Permitting and Inspections Department
Michael A. Russell, MS, Director

December 5, 2016

CBL: 020 D012001
Located At: 48 Hancock St
RE: Permit # 2015-00033 & 2016-02746

**EXISTING CONDITIONS PLAN**

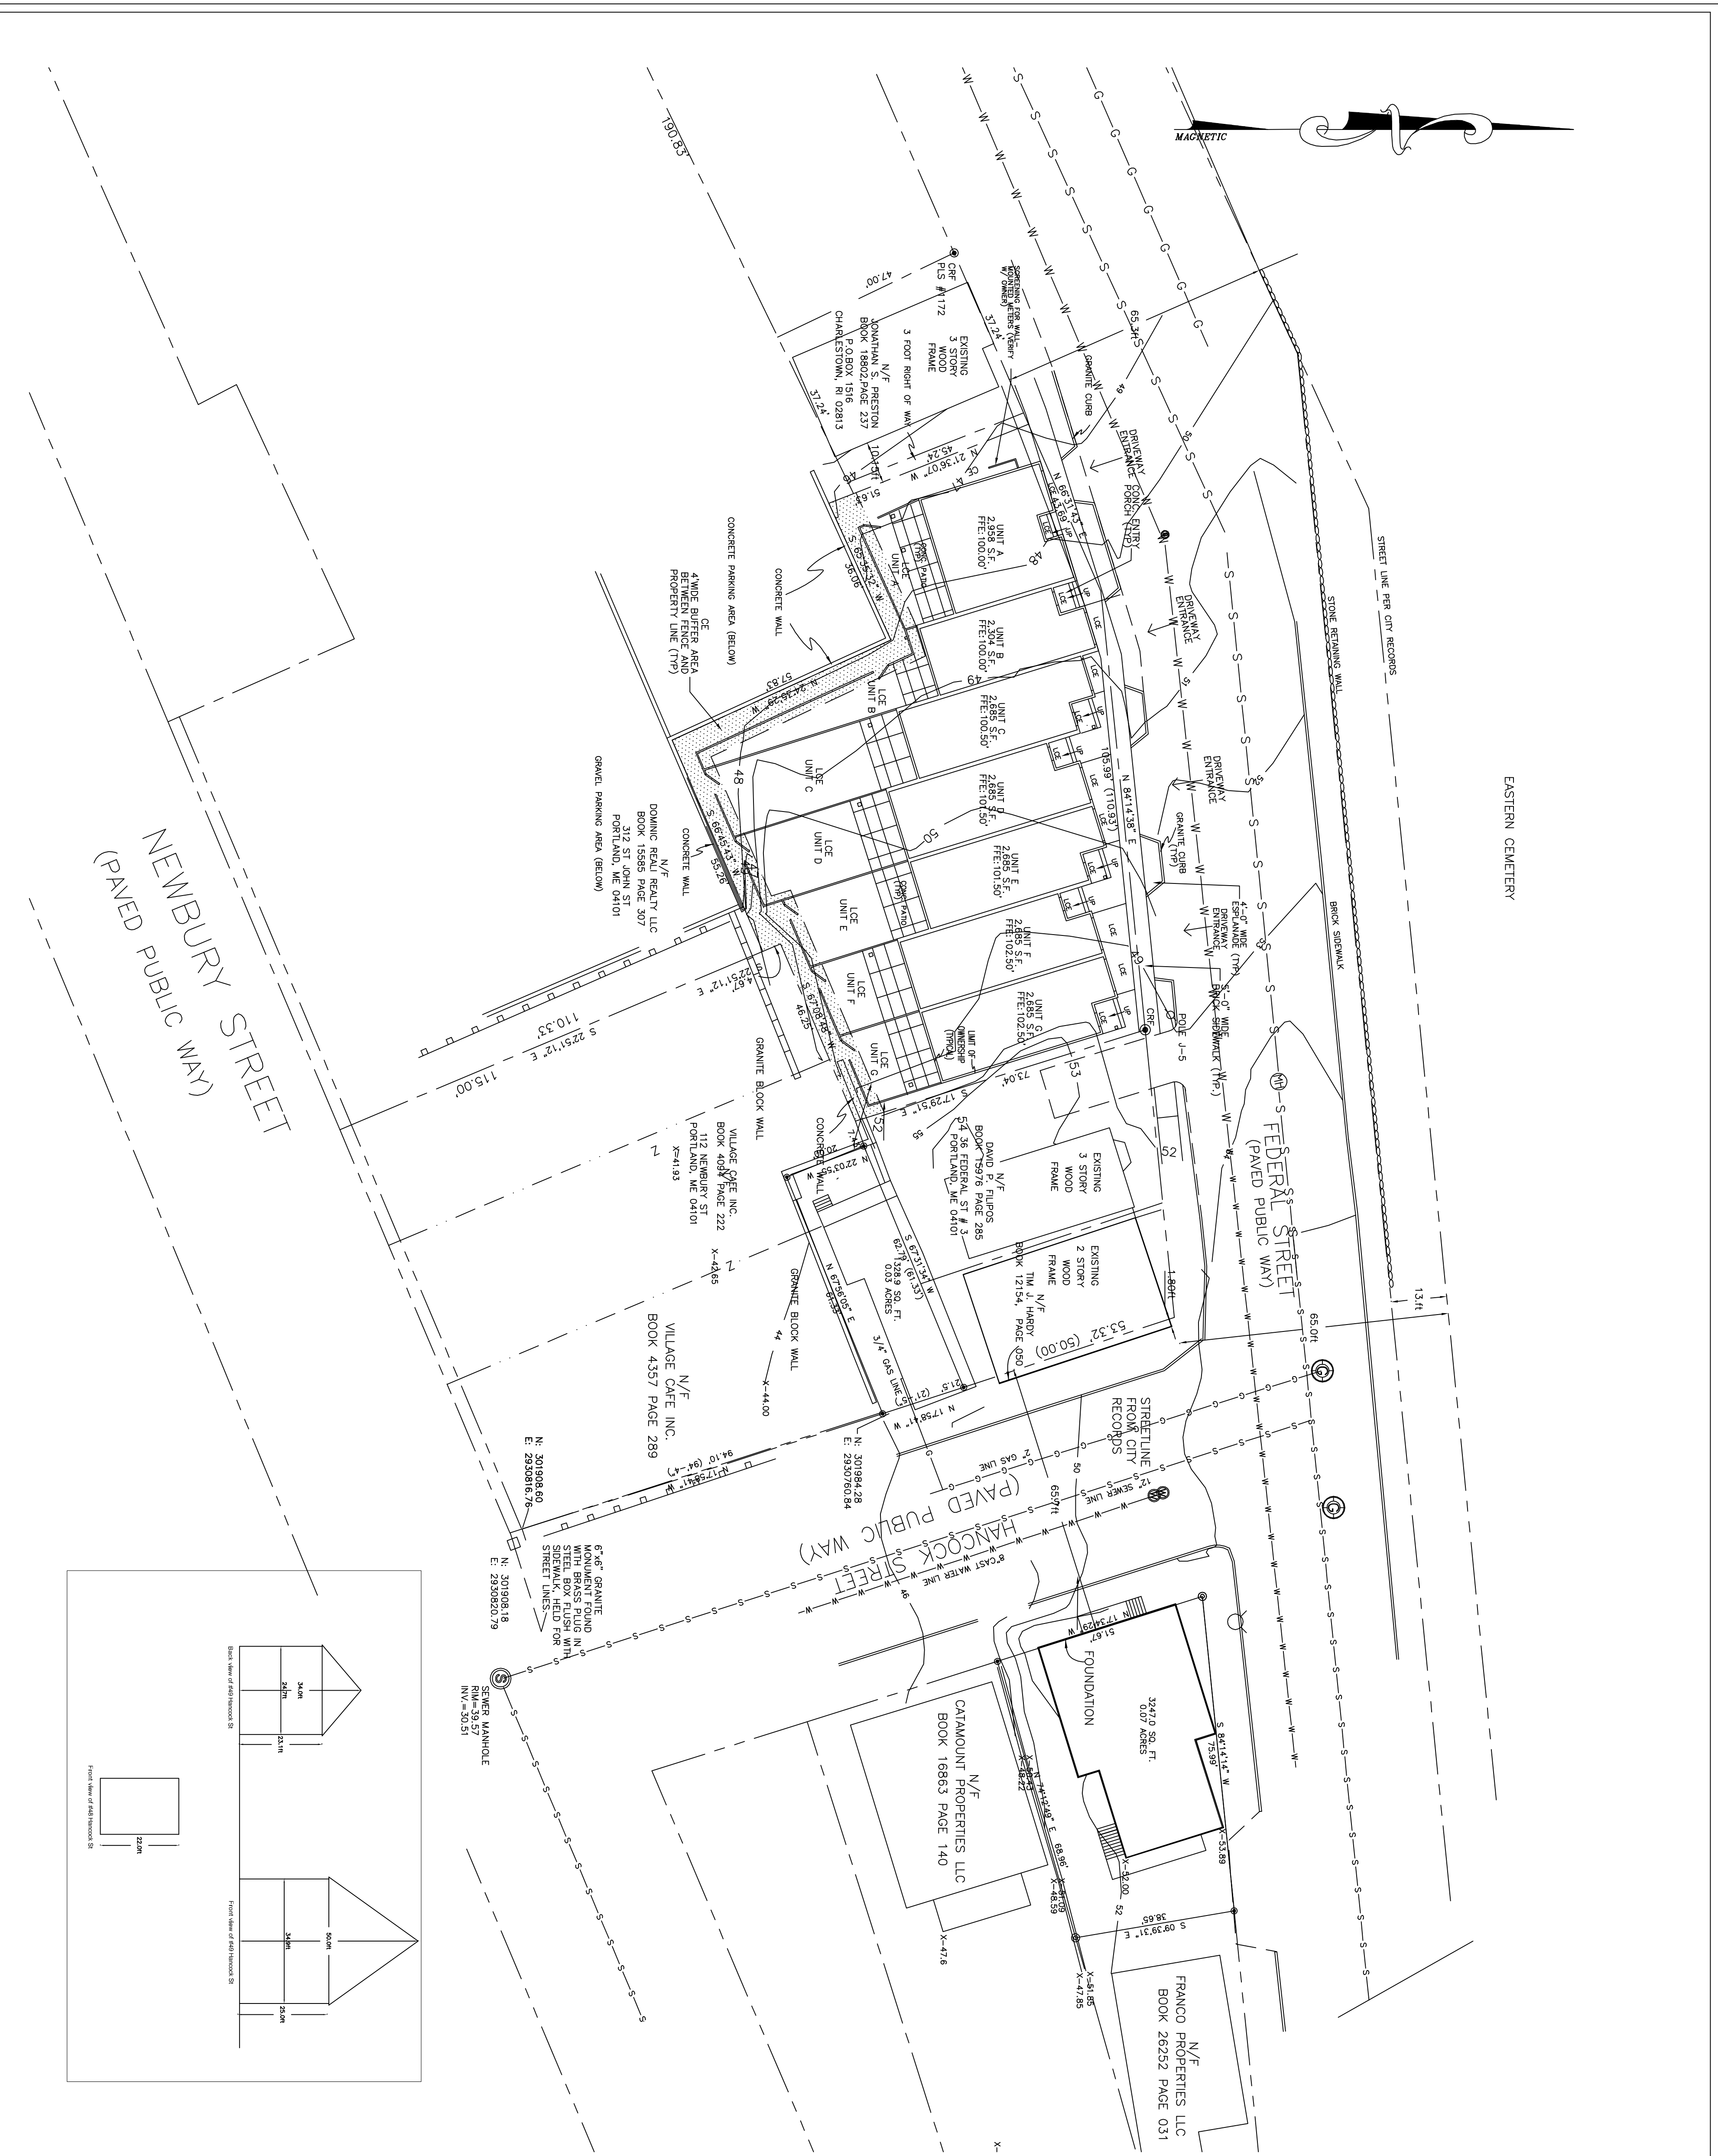
An inspection of the above-referenced property on December 2, 2016, revealed that portions of the structure - specifically, the cantilevered portion of the second floor - may already encroach on your neighbor's property, or may encroach once the final exterior finish is complete. As I'm sure you are aware, this is contrary to the approved building plans.

In order to avoid enforcement action, please provide me a plan, stamped by a State of Maine licensed surveyor, containing the following no later than Wednesday, December 14, 2016:

1. Identifying the boundary of the property and disclosing any conflicts regarding that boundary;
2. Verifying that no portion of the as-built structure extends beyond the surveyed boundary, specifically addressing the conformance, or lack thereof, of the cantilevered portion of the second floor; and
3. Verifying that no portion of the completed structure will extend beyond the surveyed boundary, again, specifically addressing the conformance, or lack thereof, of the cantilevered portion of the second floor.
